**COMMENTS ON ADDITIONAL SUBMISSIONS RECEIVED**  
**ELMESTHORPE PARISH COUNCIL**  
**10<sup>th</sup> November 2023**

**ES FIGURE 14.5 - MAIN HNRFI SITE
CONCEPT FOUL WATER DRAINAGE
STRATEGY**

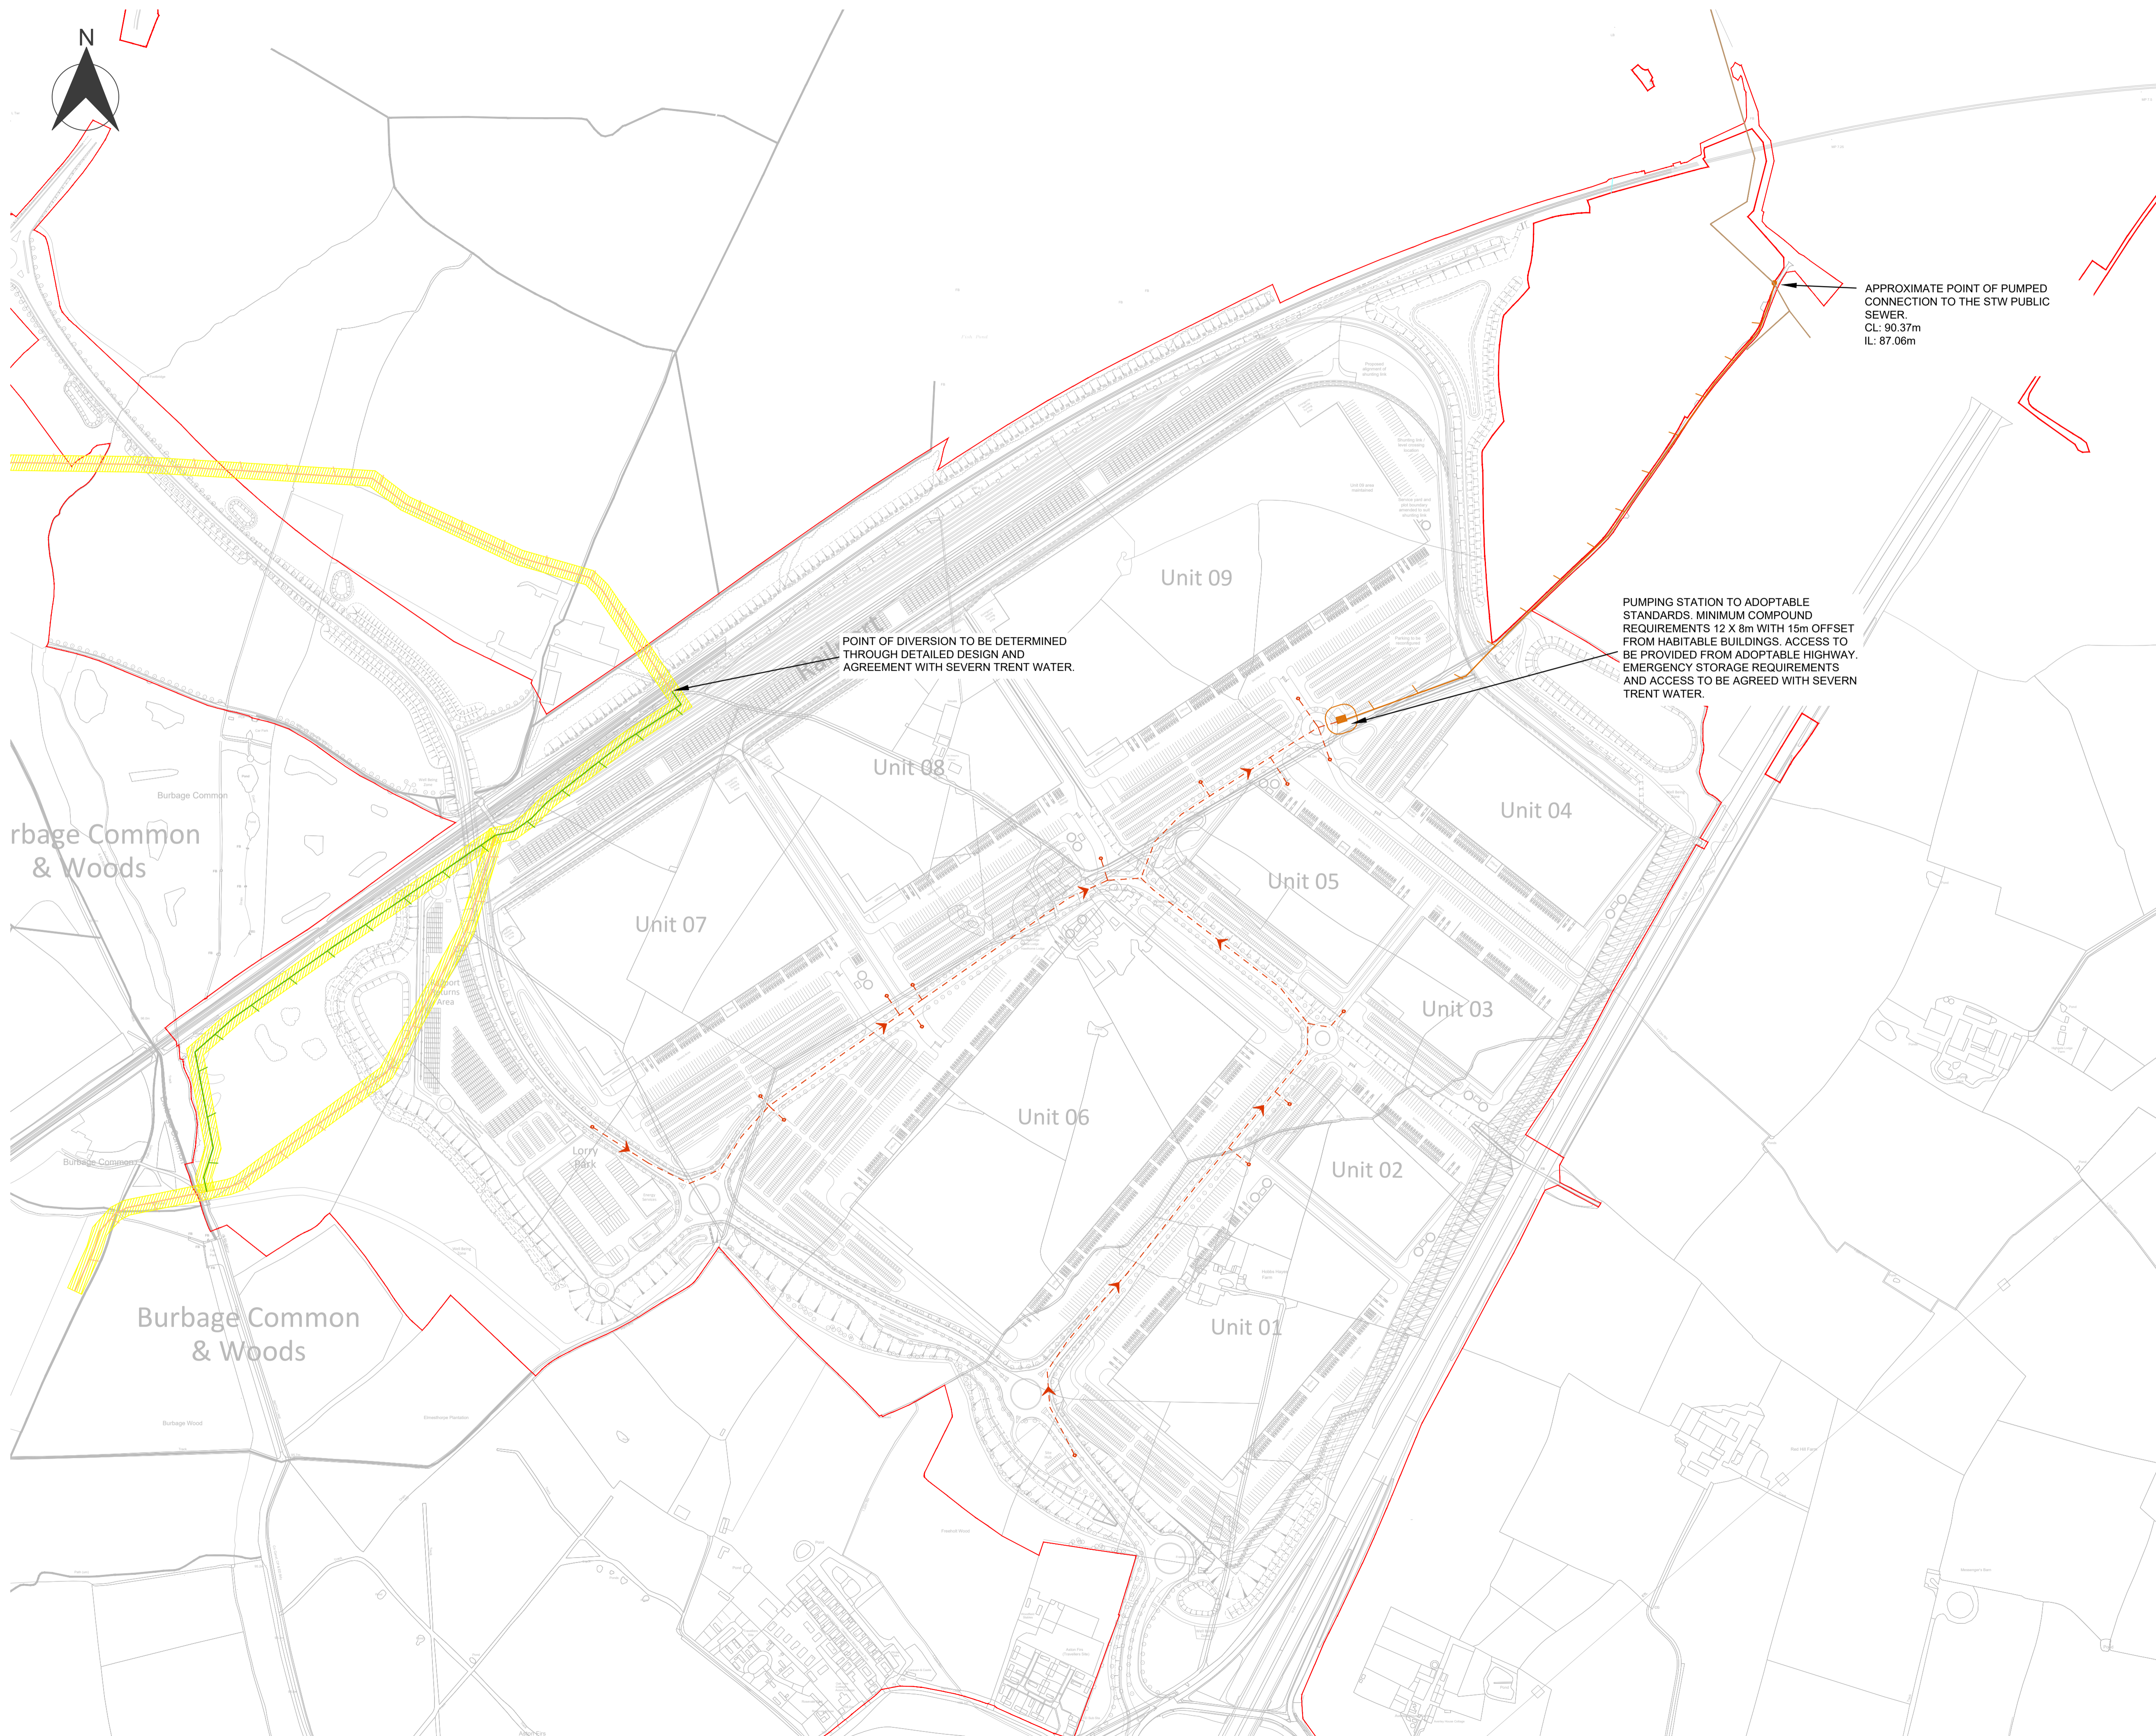
- 10.1. The Parish Council still holds concerns regarding the flood mitigation. We believe the base modelling that flood mitigation is based upon is not reflective of the actual current conditions.
- 10.2. The Parish Council also holds concerns regarding the Foul Water Network and any information as to how the HNRFI will feed into this existing old and delicate network would be gratefully received. Sewers are known to be blocked by tree roots in the village causing sewer floods into homes (Appendix 1).
